This is to certify that Fletcher-ritter Llc /Warren Construction
has permission to Warehouse Jewelry supply house. Tenant set-up
AT 46 Cove St Permit No. 010 H004001

Permit No: 04-1712	DEPT. OF BUILDING INSPECTION CITY OF PORTLAND, ME	010 H004001
Location of Construction: 46 Cove St	Owner Name: Fletcher-ritter Llc	Owner Address: 118 Preble St
Business Name:	Contractor Name: Warren Construction	Contractor Address: P.O. Box 362 South Portland, ME 04089
Lessee/Buyer's Name	Phone:	Permit Type:

Proposed Project Description:
Warehouse Jewelry supply house. Tenant Fit-up

1 FLOOR PLAN  
Scale 1/8" = 1'-0"

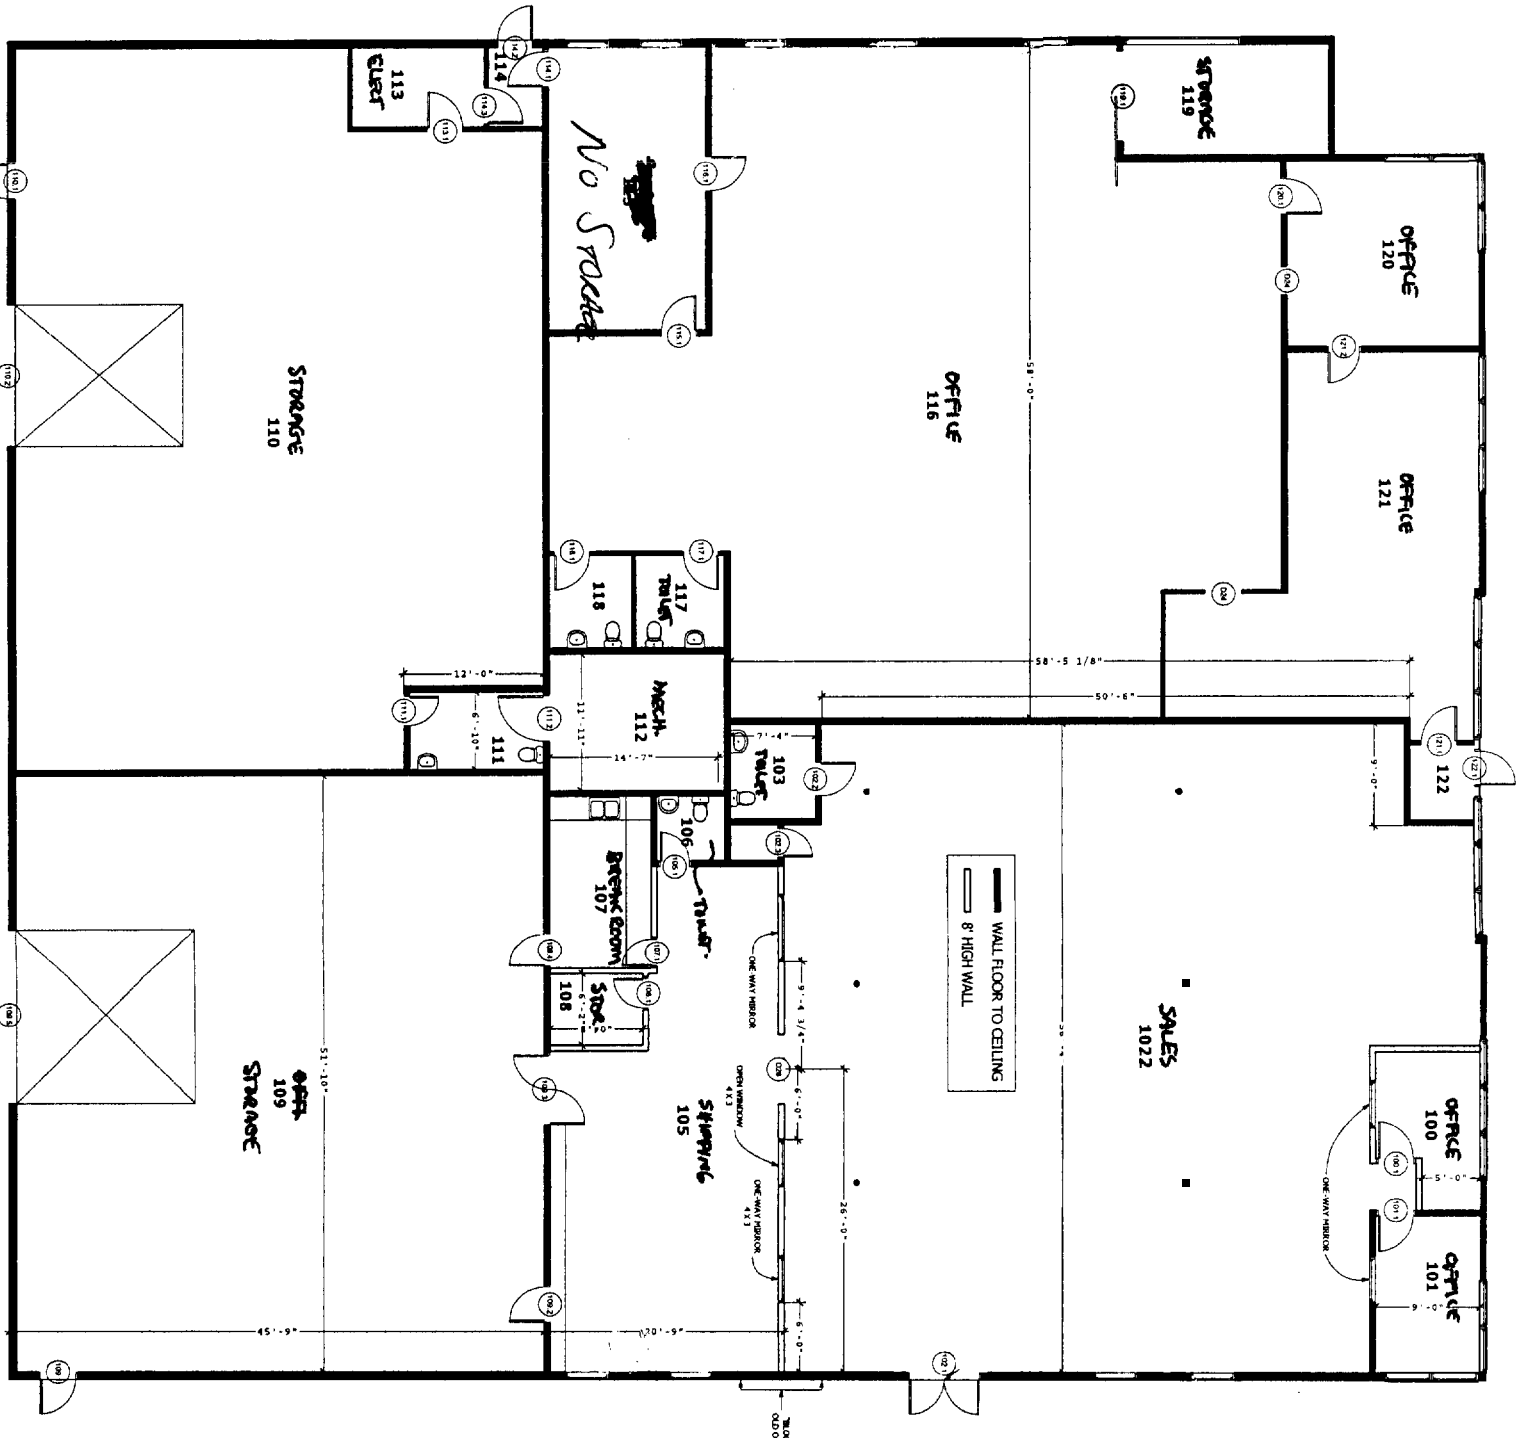
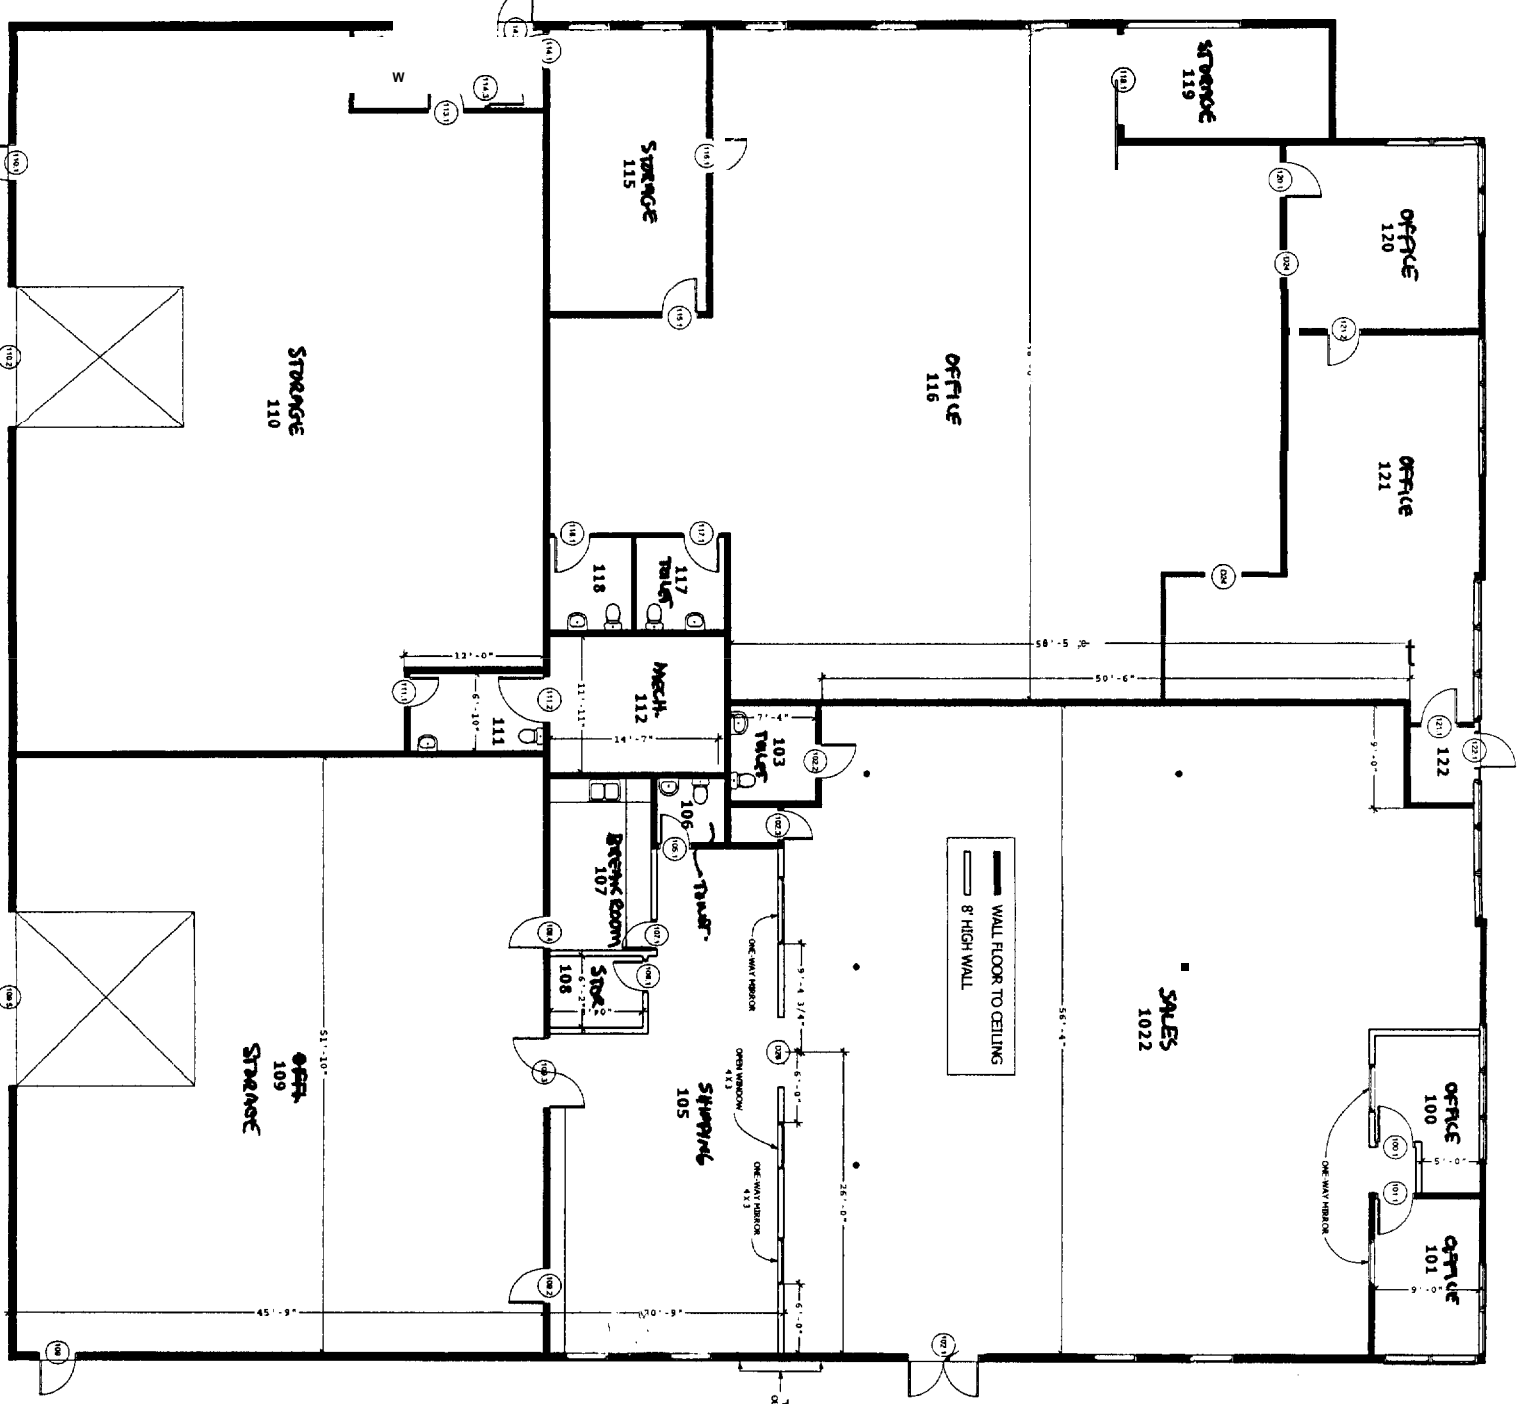
- 1) This is approved pursuant to Section 302.3.1, nonseparated mixed uses
 - 2) Separate HVAC permit is required prior to installation as no plans were submitted.
- Room 115 cannot be used as storage.
